Arun District Council
Arun Civic Centre
Maltravers Road
Littlehampton
West Sussex BN17 5LF
Planning General Enquiries
Tel: (01903) 737756 Fax: (01903) 730442
Dx: 57406 Littlehampton
Minicom: 01903 732765
e-mail: planning@arun.gov.uk
website: www.arun.gov.uk/planning

11 October 2016

Town & Country Planning Act 1990 (as amended)
Town and Country Planning (Development Management Procedure) (England) Order 2015
Application for approval of details reserved by condition imposed under BR/54/16/PL relating to
condition No. 7 (Construction management plan), 10 (Surface water drainage), 12 (Watercourse), 14
(External lighting scheme), 15 (Noise), 16 (Public sewers), 17 (Foul & surface water sewerage
disposal), 18 (Cars), 19 (Roof plant), 23 (Landscaping scheme), 24 (Tree retention & protection plan),
25 (Programme of archaeological work & scheme of investigation), 26 (schedule of materials) & 34
(Programme of ecological work)
University of Chichester Upper Bognor Road, Bognor Regis,

Arun District Council have decided to **REFUSE details reserved by condition for the following reasons:**

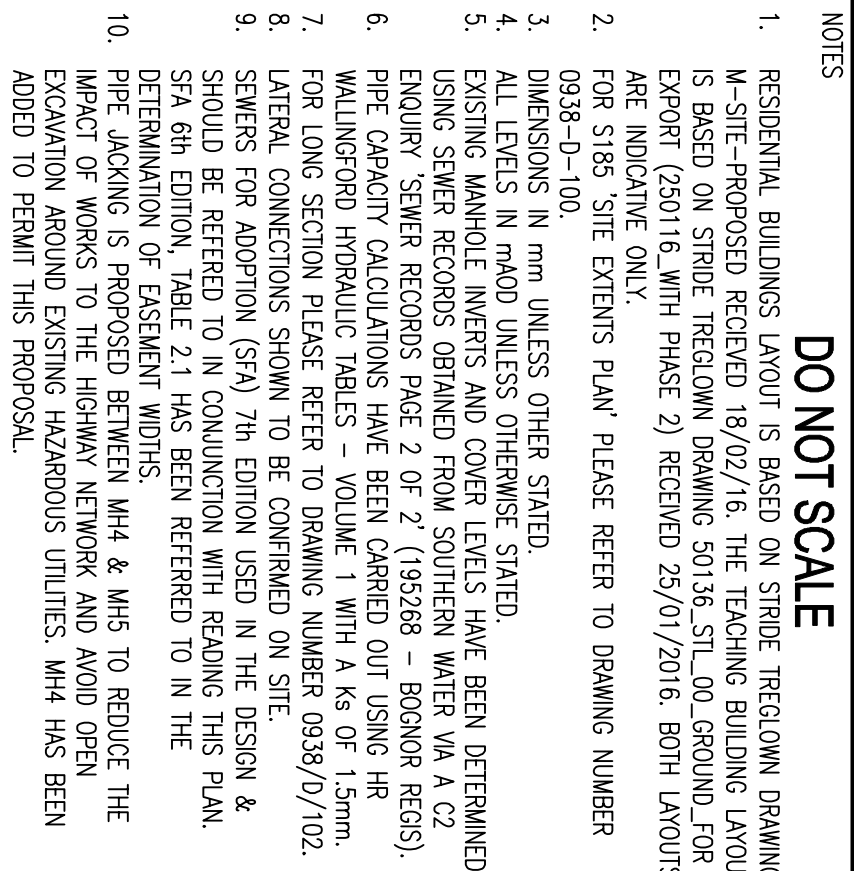
The sewer diversion proposals should be agreed and approved by Southern Water under s185 of the Water Industry Act before condition 10 can be discharged.
